From: Amanda Scholes
Sent: 22 June 2020
To: Sian Eggington
Subject: FW: Request for further information R/107/20/HH

'RUSSETTS', 25 SEA AVENUE, RUSTINGTON - YOUR REF: R/107/20/HH

SITE LOCATION PLAN
1:1/250

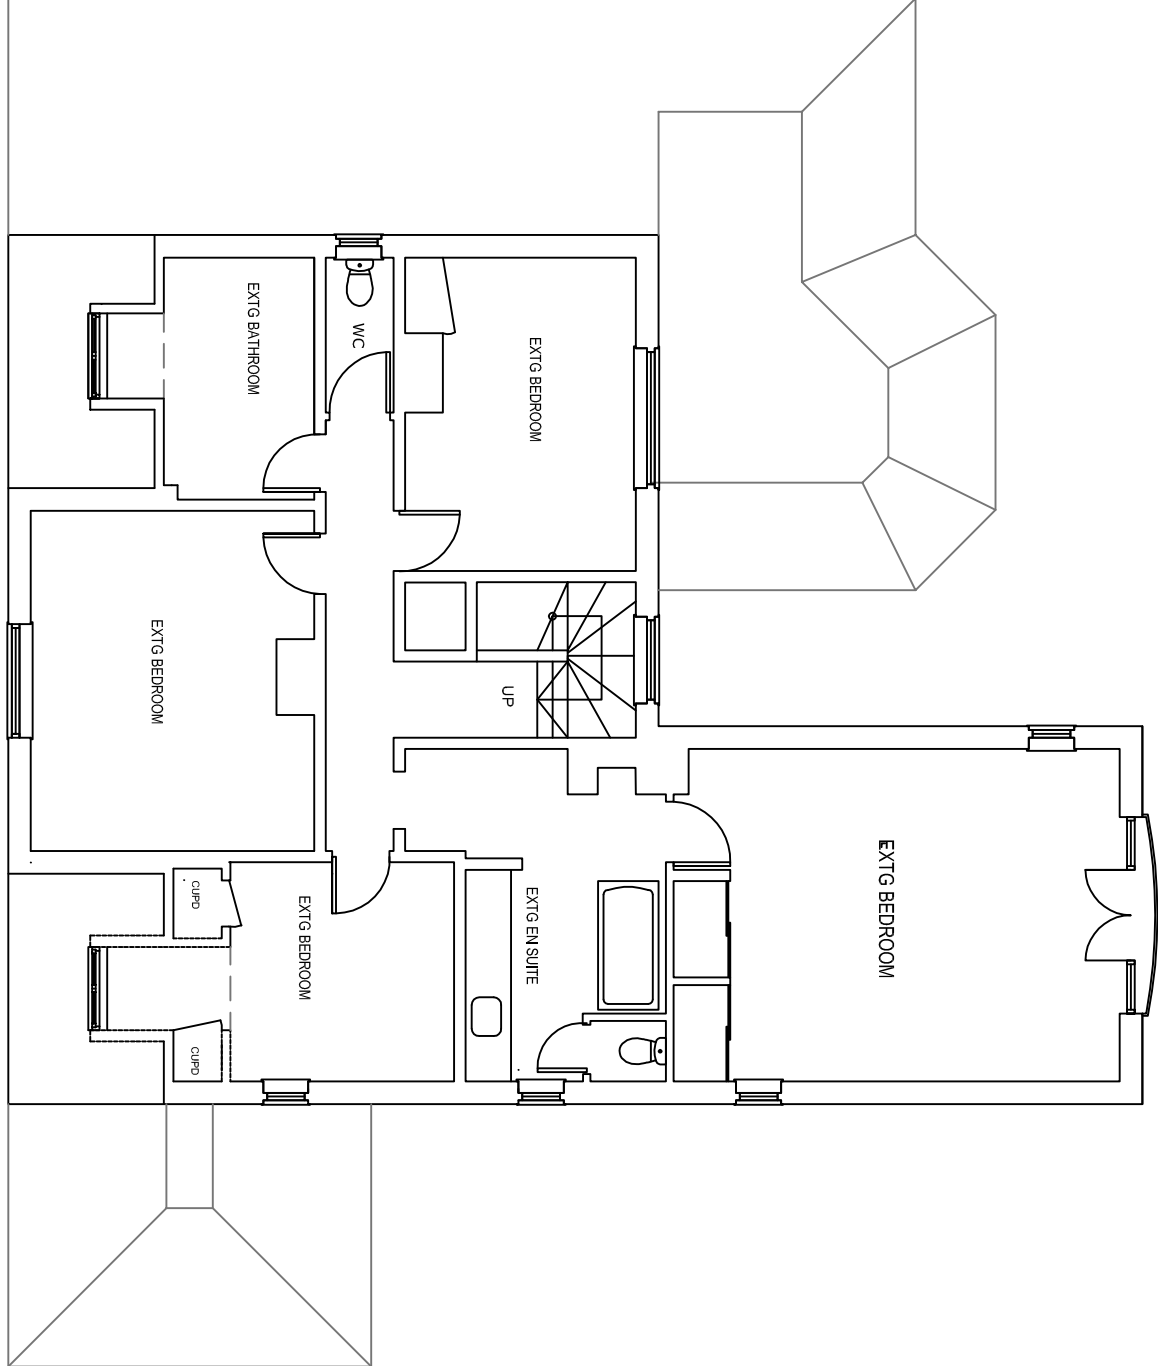
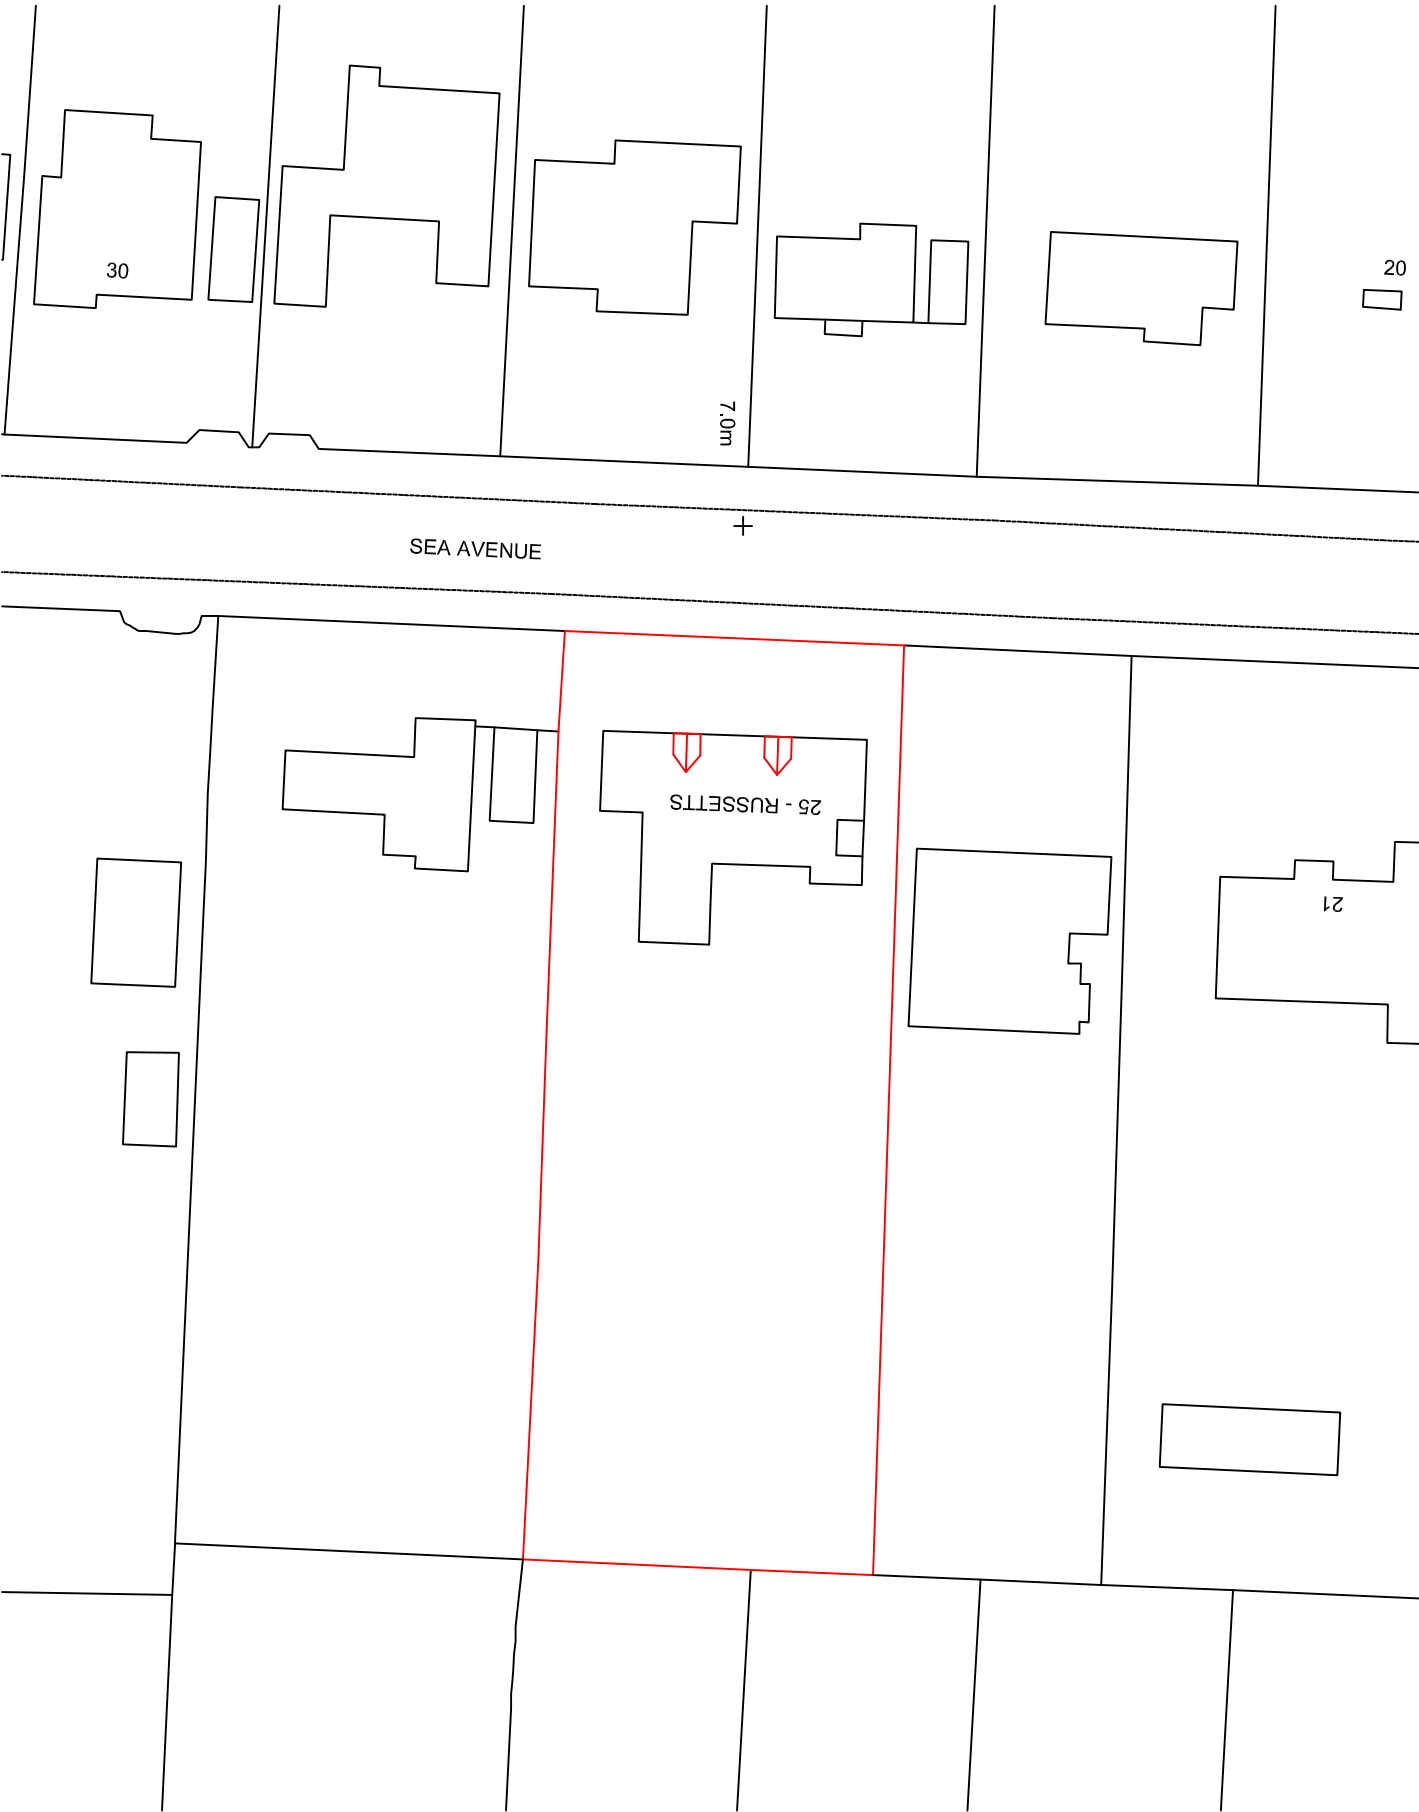
I have checked our drawing and cannot see where the red outline crosses over the neighbouring boundary that you refer to.

I have also checked with my client and they have confirmed the boundary as shown in red on the drawing is in the correct position (please note the new dormers are also outlined in red).

To make the drawing clearer, I have removed the 10m grid which may have made legibility confusing - please see dwg 230-01A attached.
